CITY OF ALBUQUERQUE

**RE: Los Pastores Shopping Center & McDonalds
Montgomery/Wyoming
DMP Addendum 3
Engineers Stamp Date: 3/26/2019,
Hydrology File: F19D013C & F19D013A**

Based on the information provided in your submittal received on 3/26/2019 the DMP Addendum cannot be approved until the following comments are addressed.

Drawing file: ESC / 2014052 G&D SHT GR1.pdf

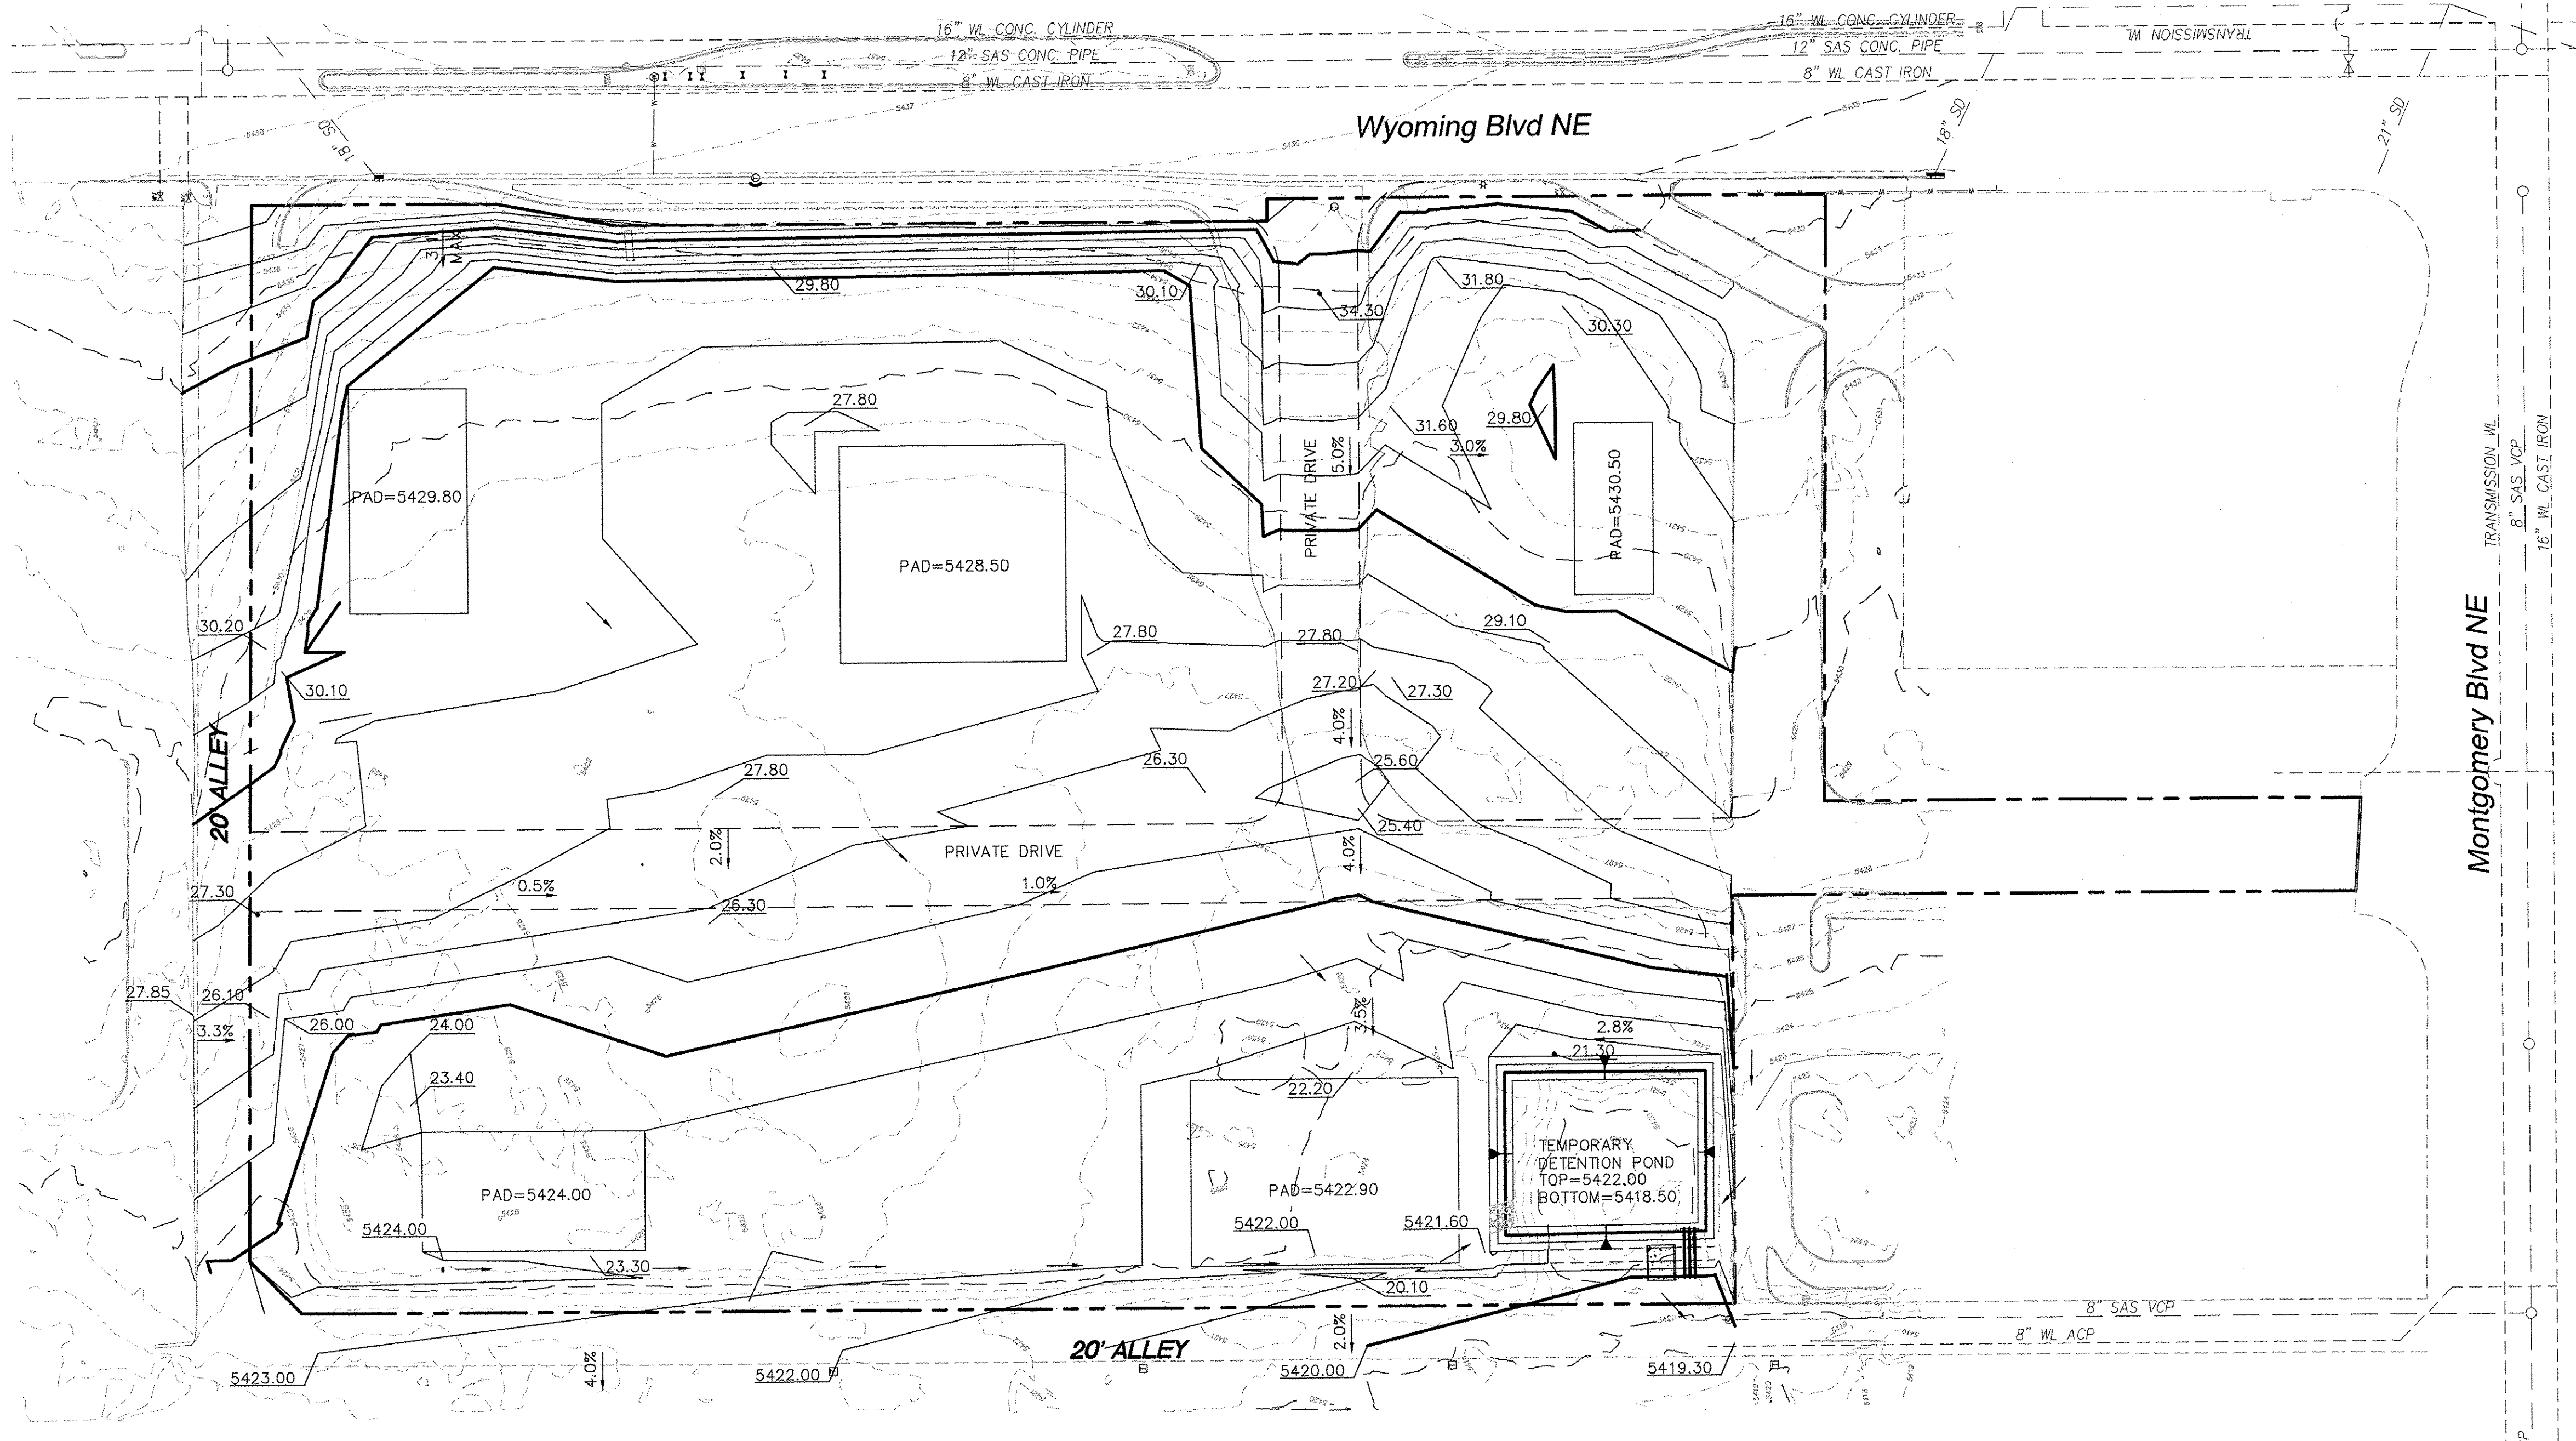
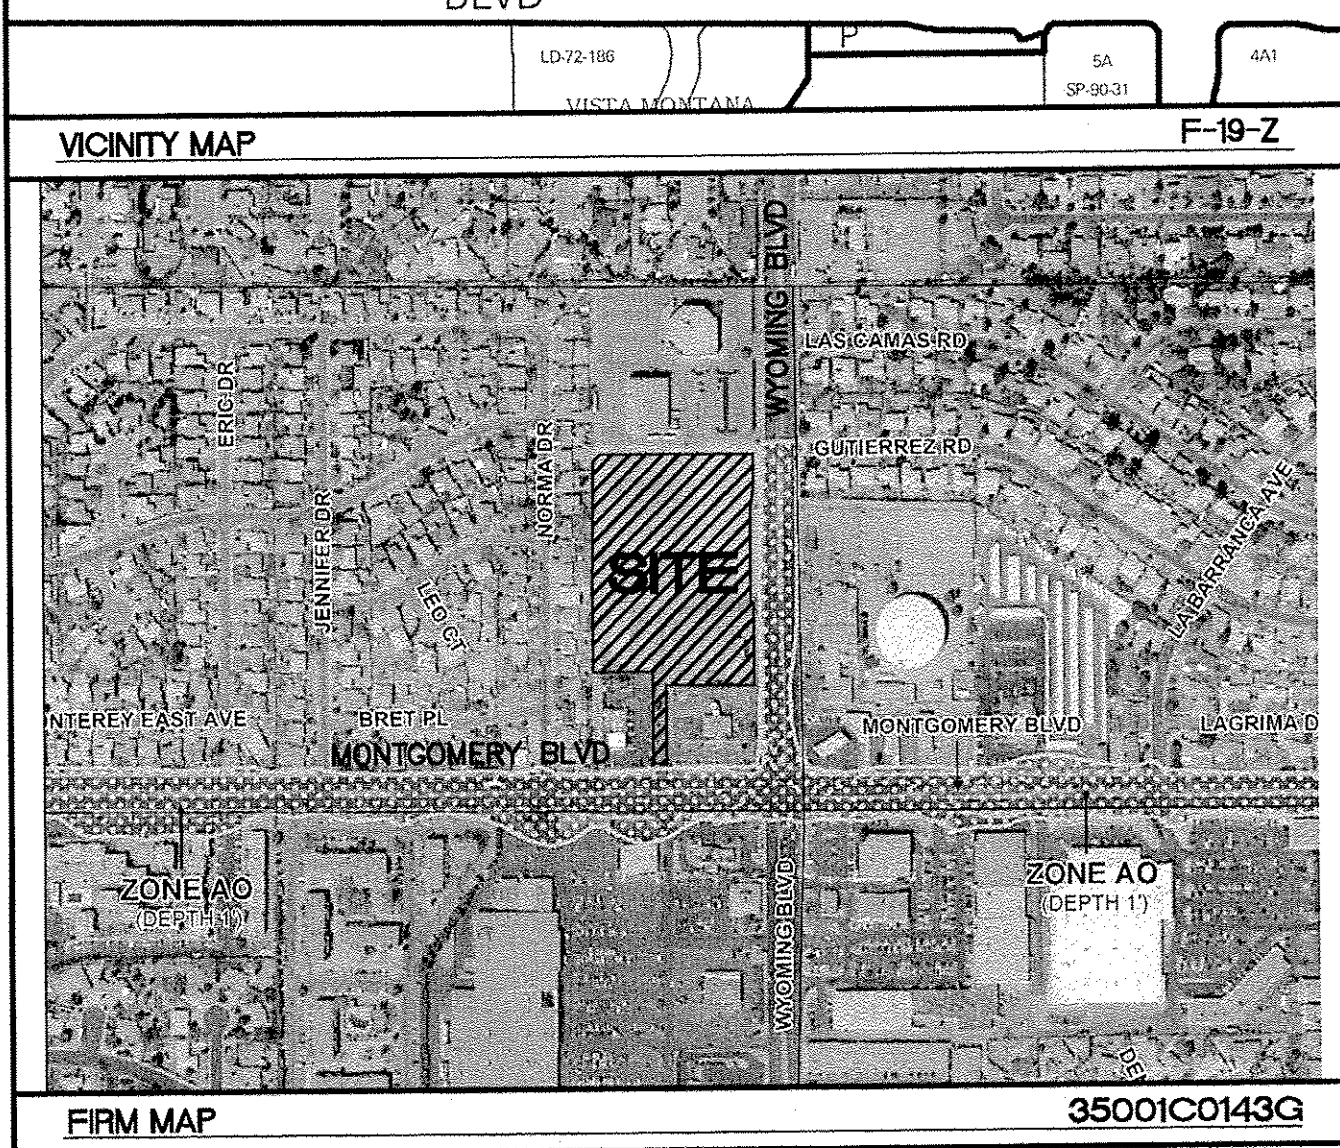
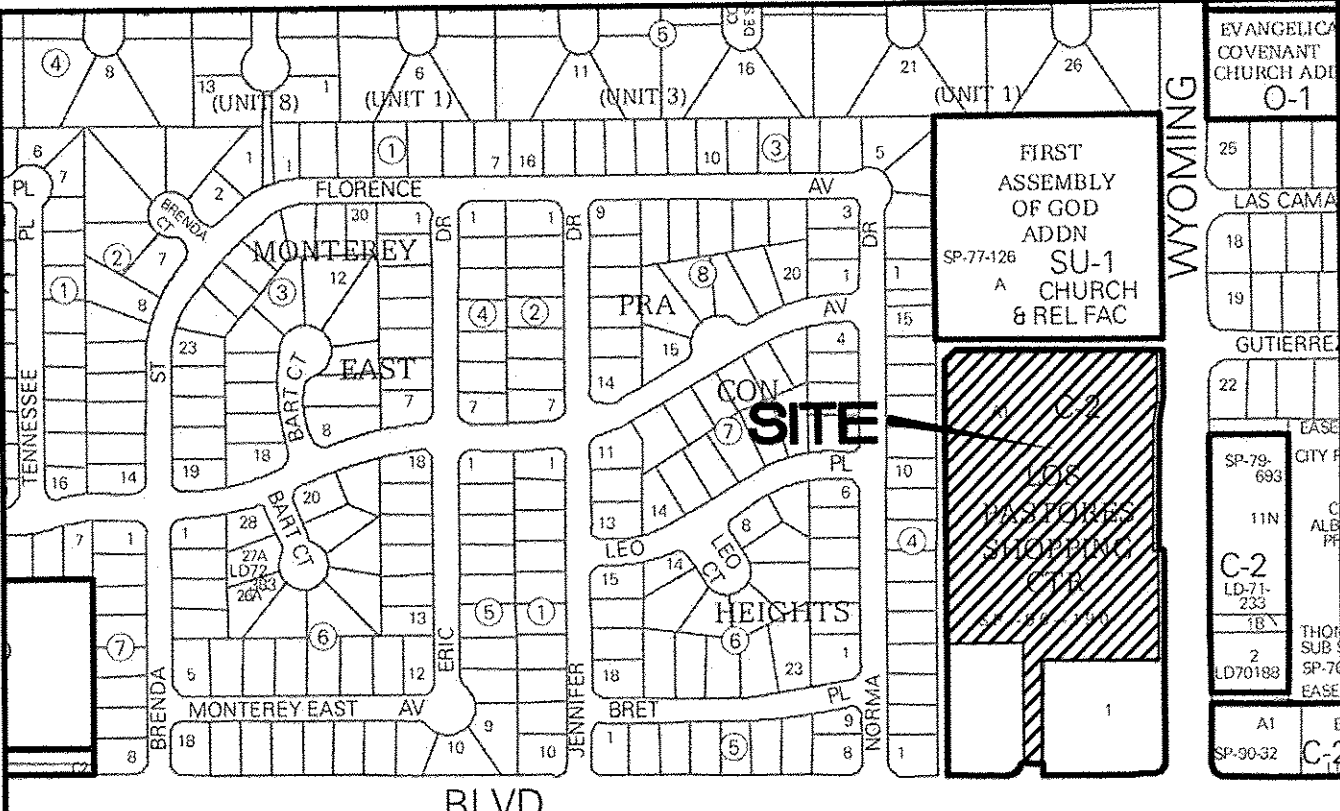
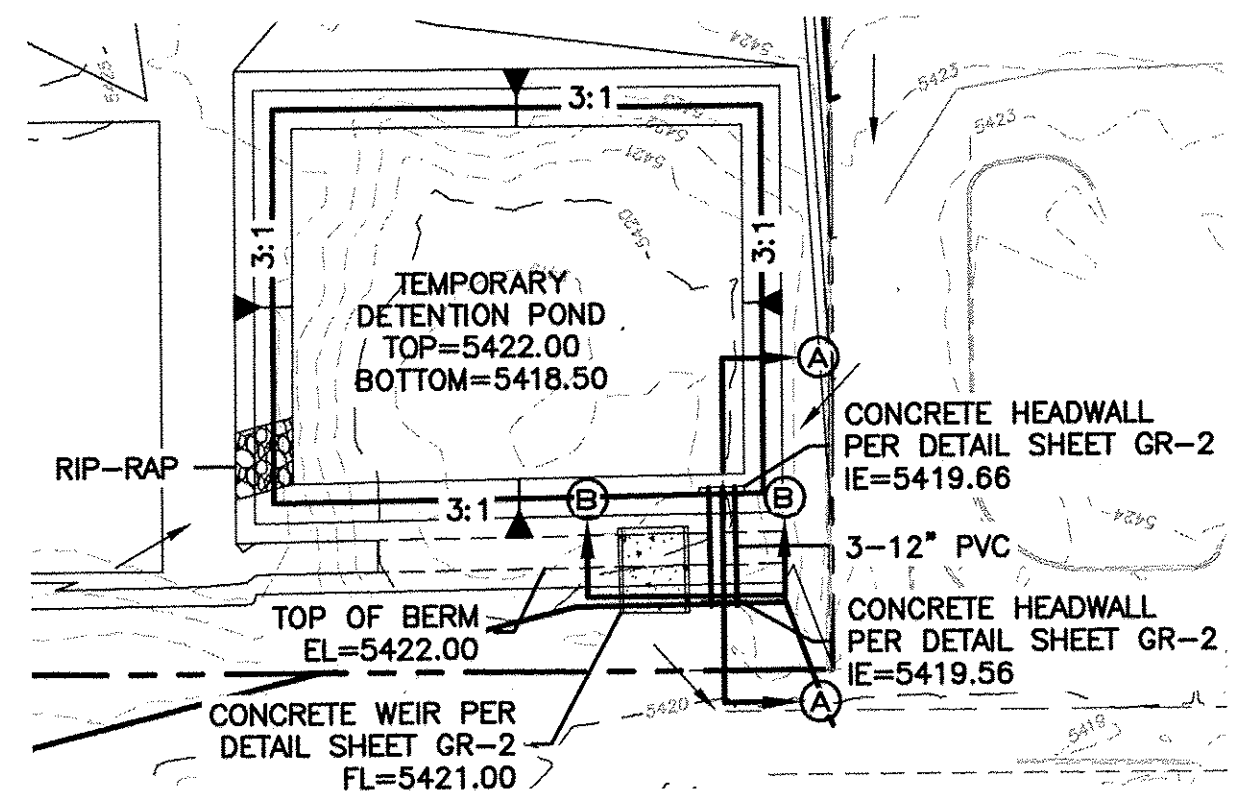
6. Please label the contours better on the pond grading detail. The bottom of the pond, Elevation 5418.5, appears to be 70' x 55' and the top, elevation 5421.93, is 88' x 73' but the area used in the volume calculations for the top of the pond is larger by about 5' in each direction. Please resolve the discrepancy by either changing the volume calculations or by changing the drawing.

13. Show the calculations of the required SWQV and include a statement next to the pond on sheet GR-1 specifically identifying which impervious surfaces are being served.

14. Add a note on Sheet GR-1 near the pond stating that the pond is already constructed as shown on the plan and that no new pond construction is proposed. Provide an engineer's stamp and signature on sheet GR-1.
